3rd April 2022

TR010025 – 002292 Re-Determination of the Application by National Highways (formally Highways England) for an Order granting Development Consent for the A303 Amesbury to Berwick Down – Unique Reference 20020916

## 2 Objector's Alternative Routes

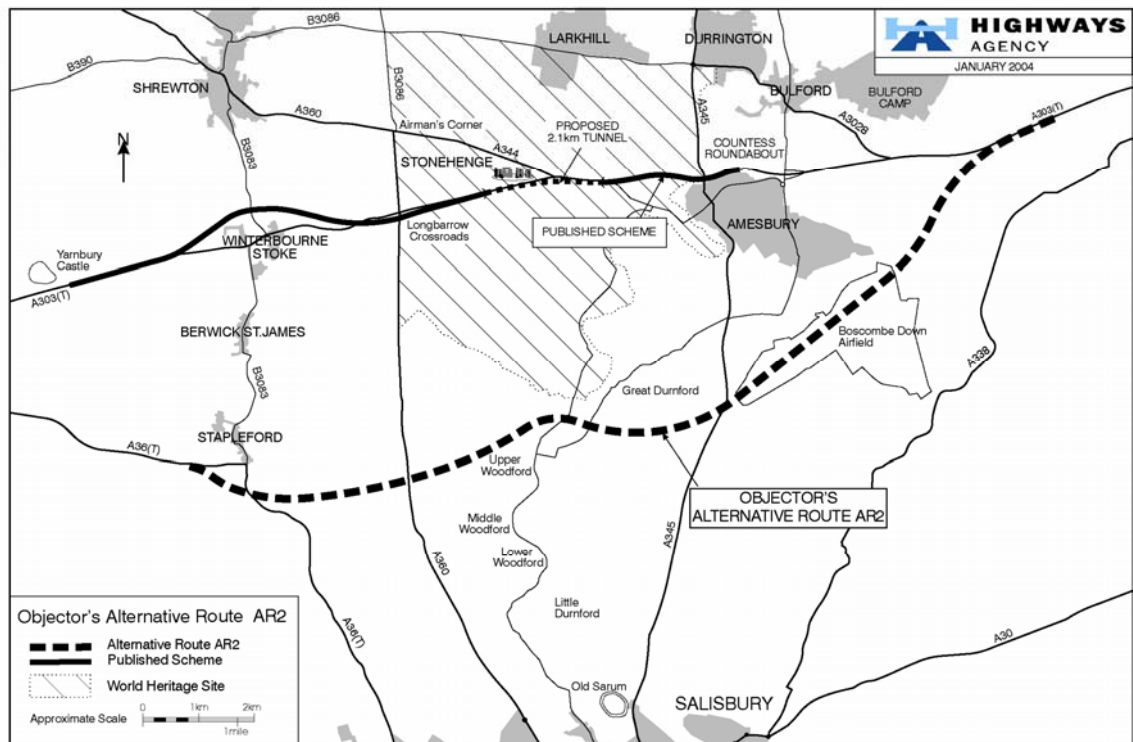
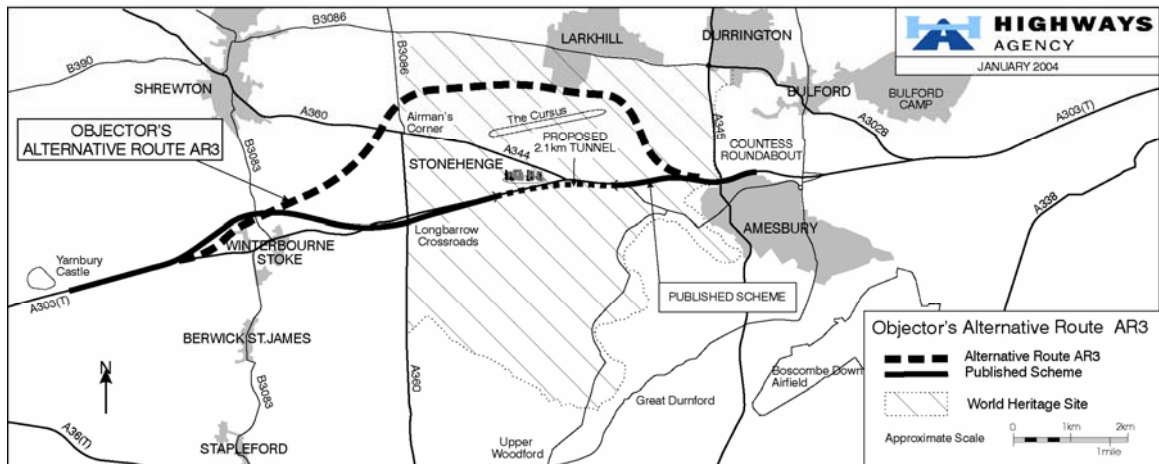
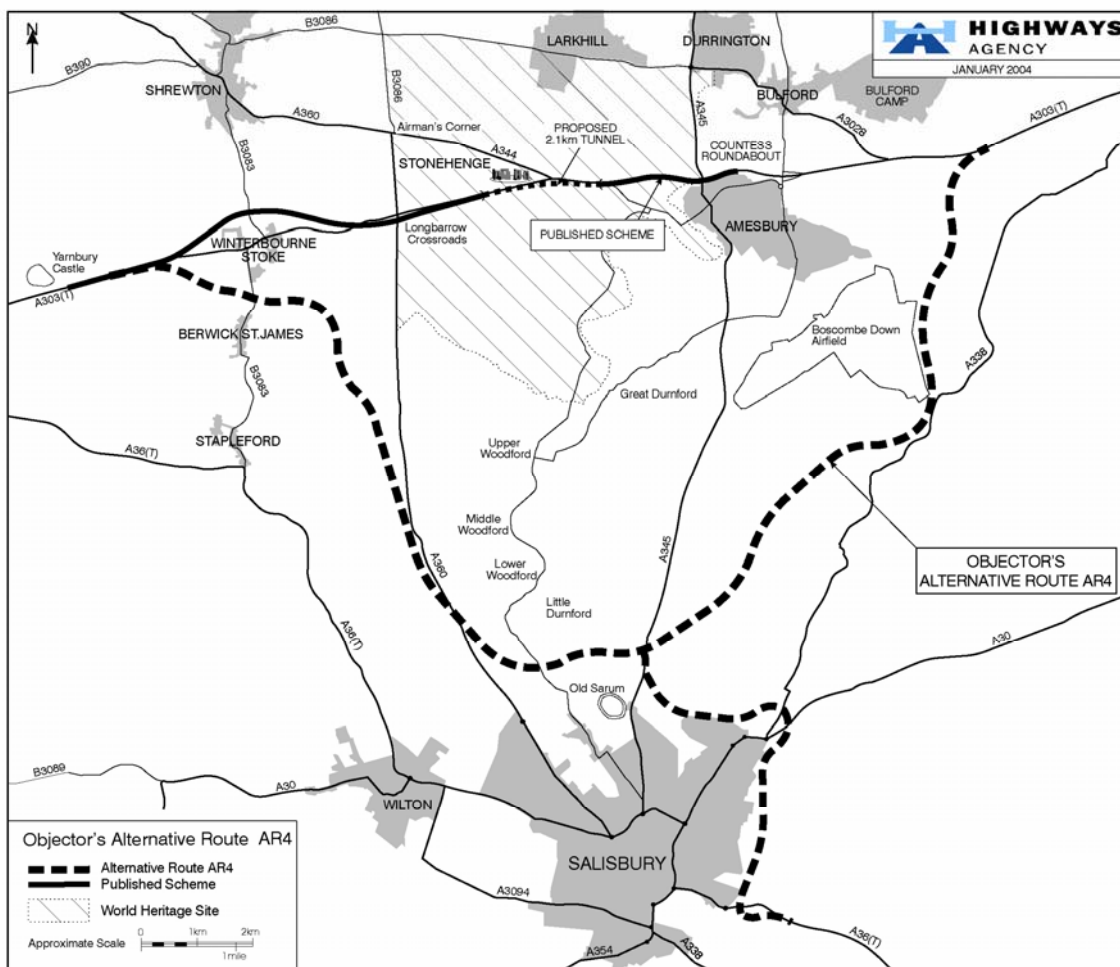
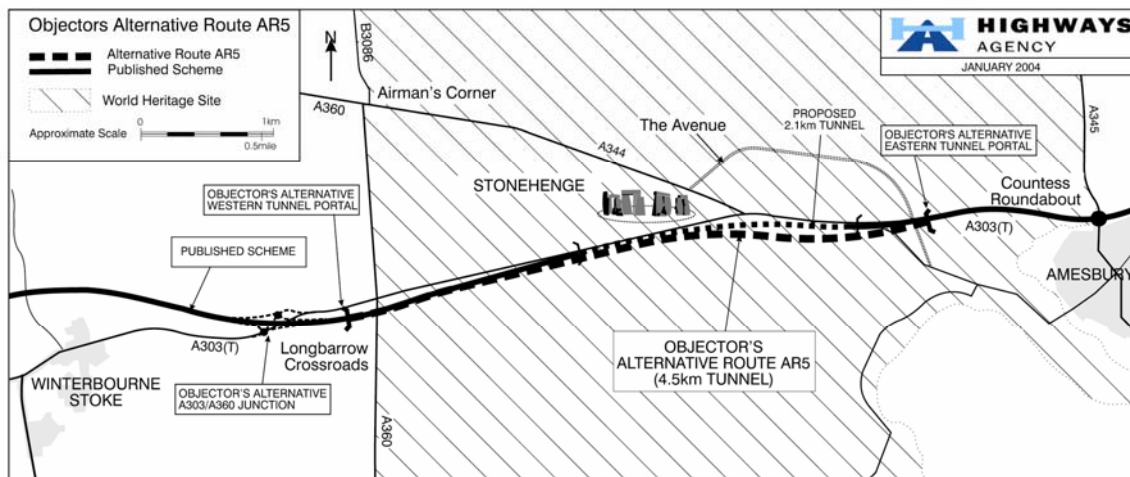
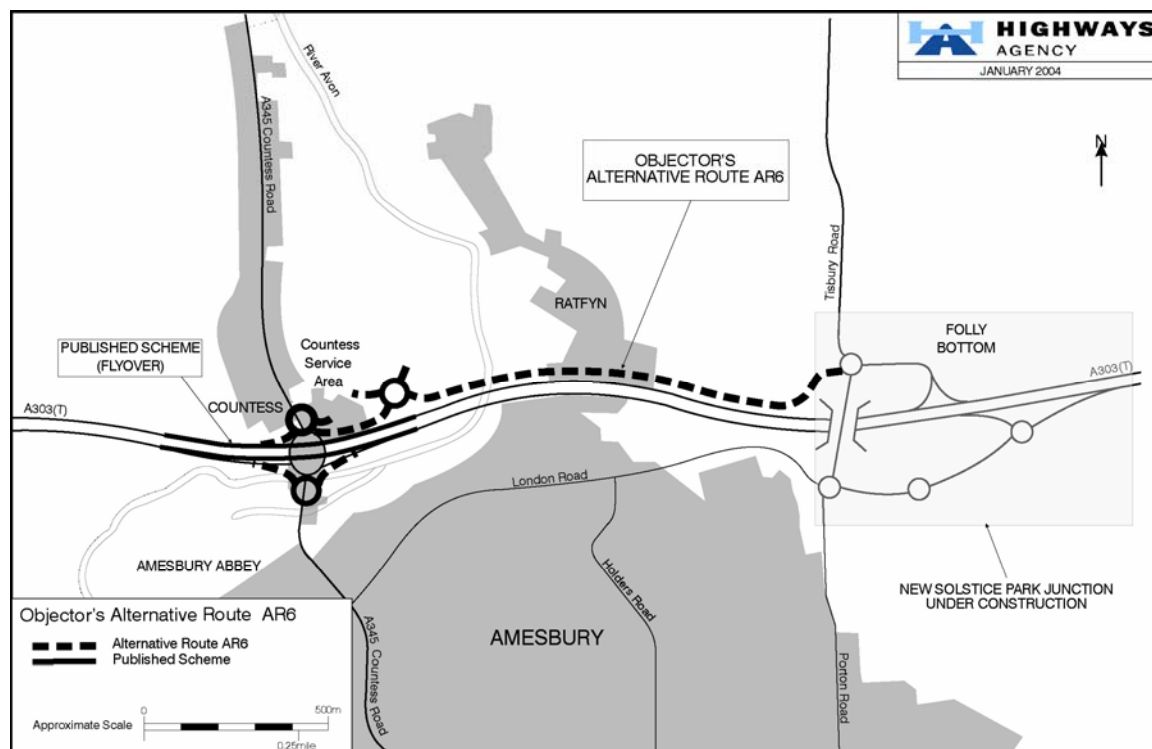
3. The alternative route that I presented to the examining body in July 2019, was not considered fully with regards to its ability to reduce traffic movement of freight from Southampton and provide a cost effective solution to provide regional transport improvements, thereby satisfying RIS 2 and future regional needs for freight movement from the docks and across Wiltshire.

4. It is the principle of the alternative route that I put forward, not a detailed design showing the precise route the road would take. With careful consideration this alternative route could utilise existing byways and roads, enable the removal of unsightly power lines, avoid AONB sites and could address the points the applicant has used to eliminate the route without consultation.

PROPOSED BORED TUNNEL - (WORK No. 1F)

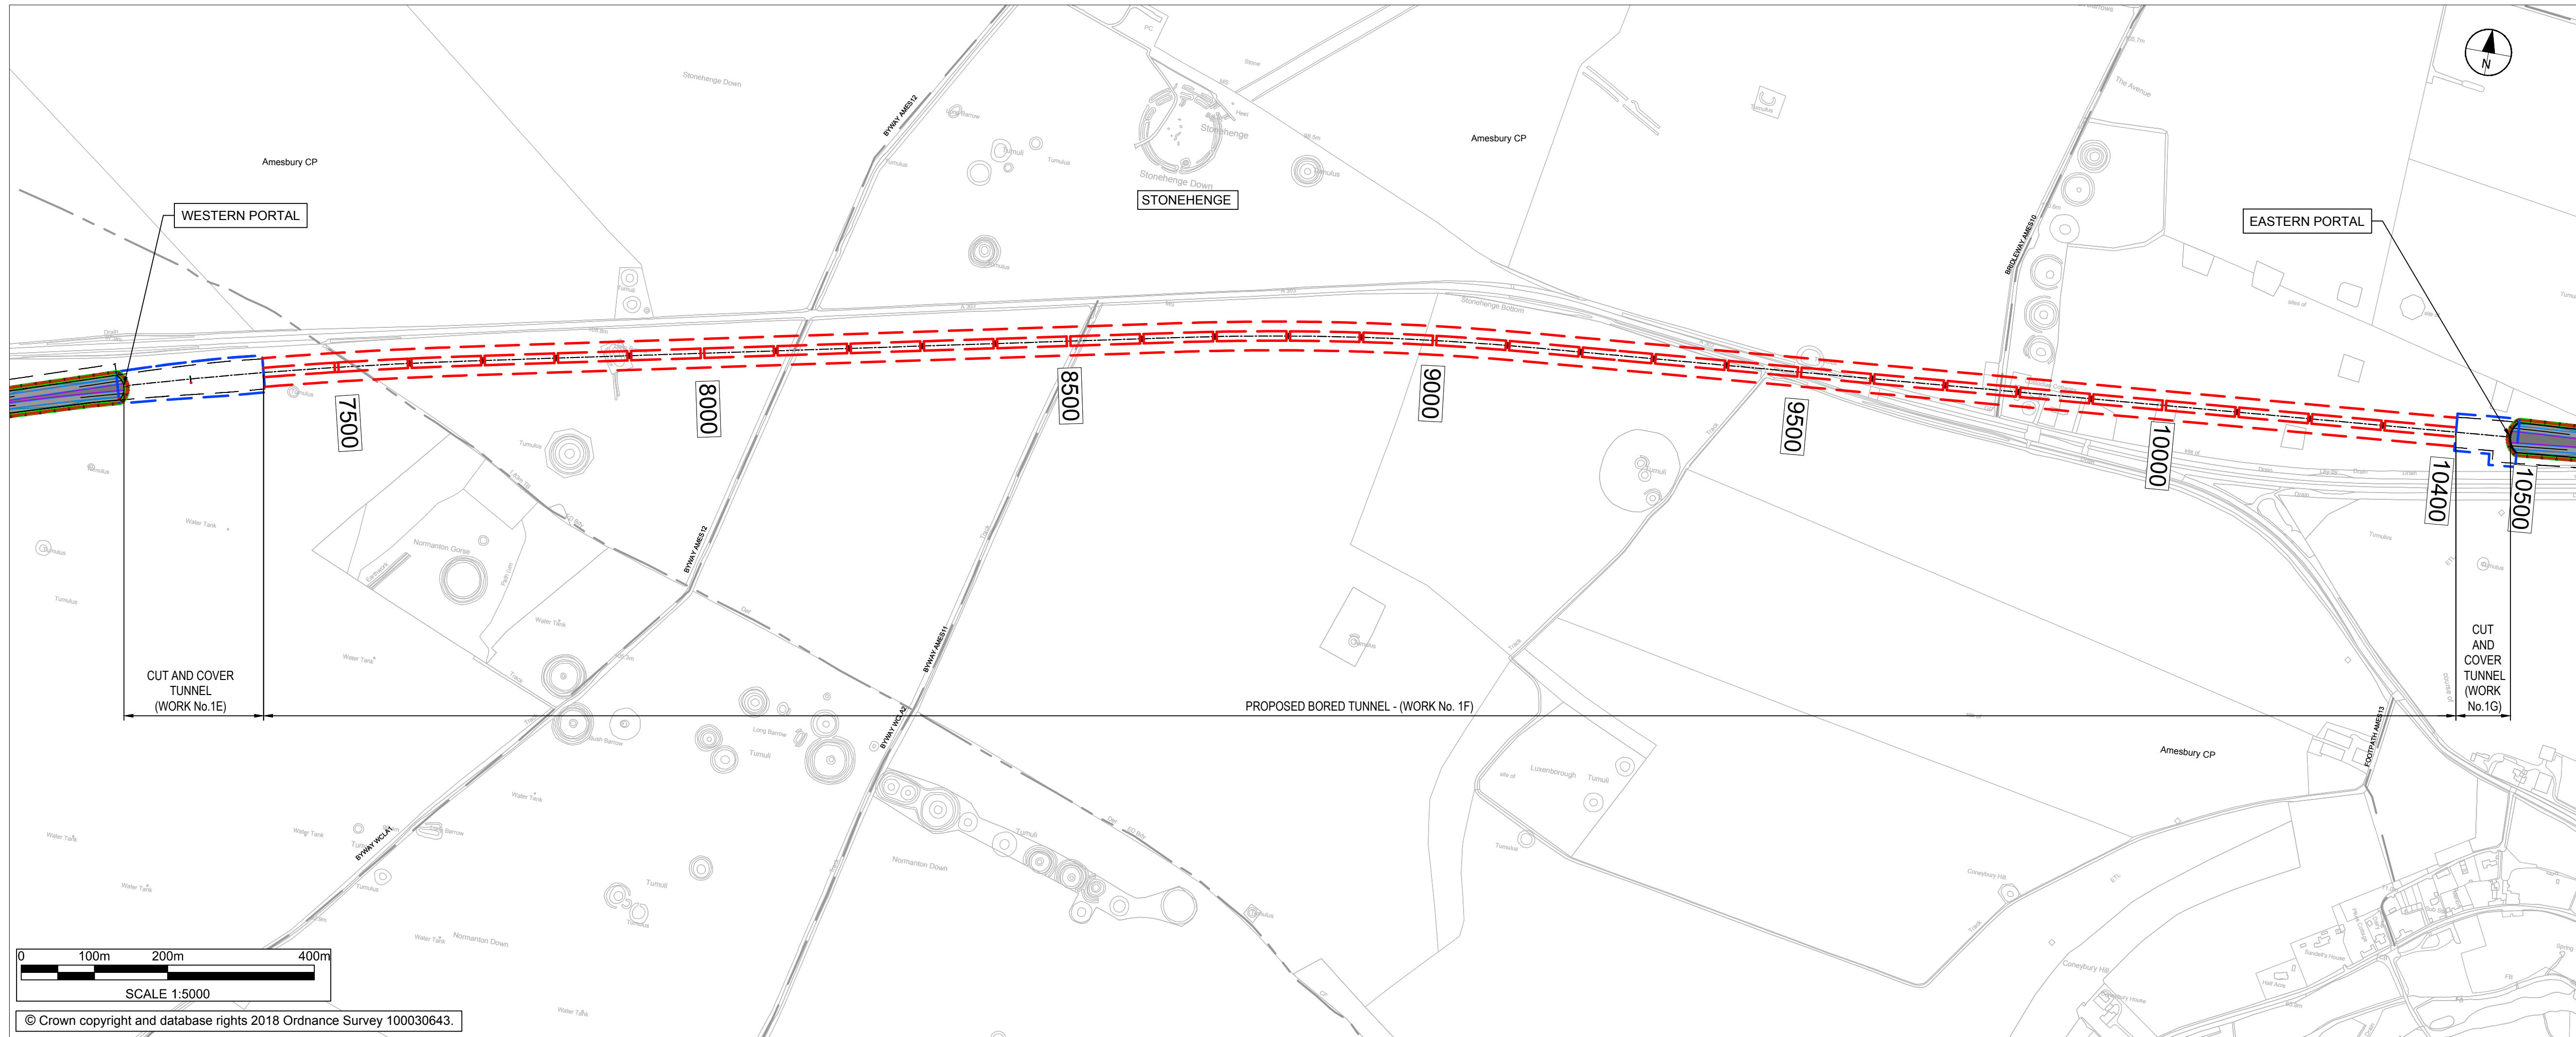
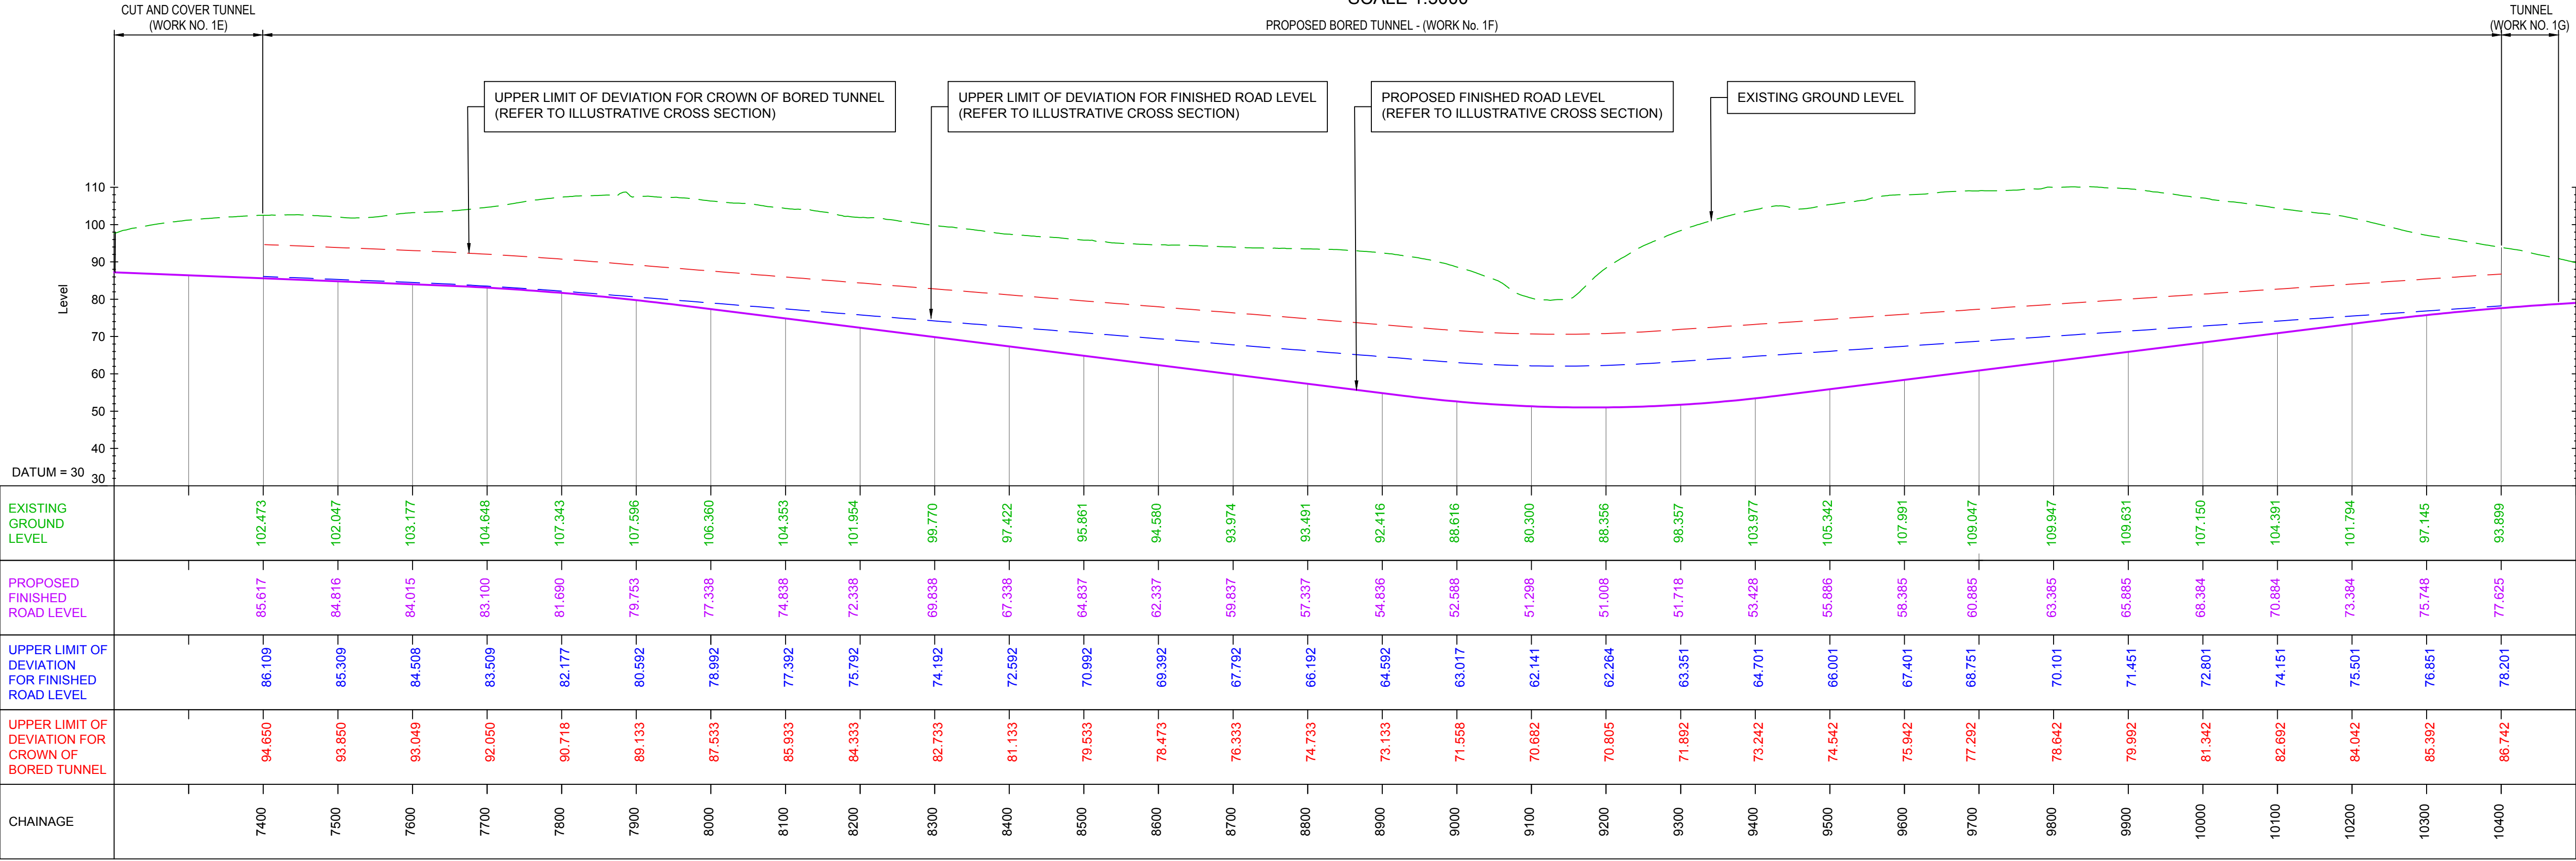
6. The Applicant has failed to show any lifetime costings within this scheme. There appears to be no program to maintain the water table when the tunnel ceases to be in operation. This fundamental detail has been missing from the first proposals, places huge problems and cost implications for future generations to address and resolve.
